Norwich to Tilbury
ISH 4 25 June 2026
Written Post-Hearing Submission

General Aviation Awareness Council
[REDACTED]

The relative locations of Tibenham and Priory Farm Airfields
The proposed route alignment and the Tibenham safeguarding zone

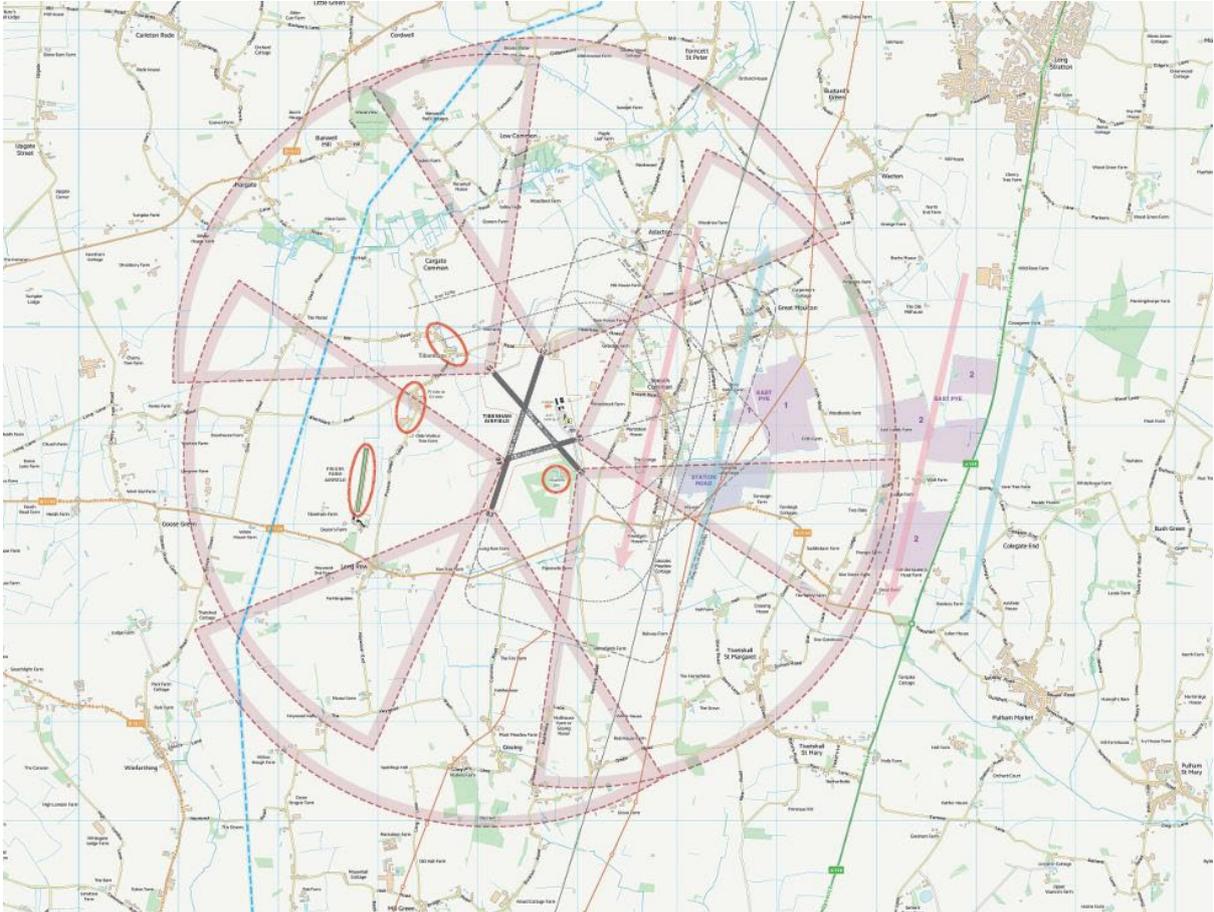
'To some extent, the impacts to Tibenham and Priory farm are interlinked and complex, owing to their close proximity to each other'

Yet only a few weeks after receipt of that report in 2025, the Applicant published their simplified Aviation Impact Assessment that ignored that expert advice and concluded that, in respect of Tibenham:

'An aerotow combination would have sufficient room to manoeuvre away from the OHL after take-off'
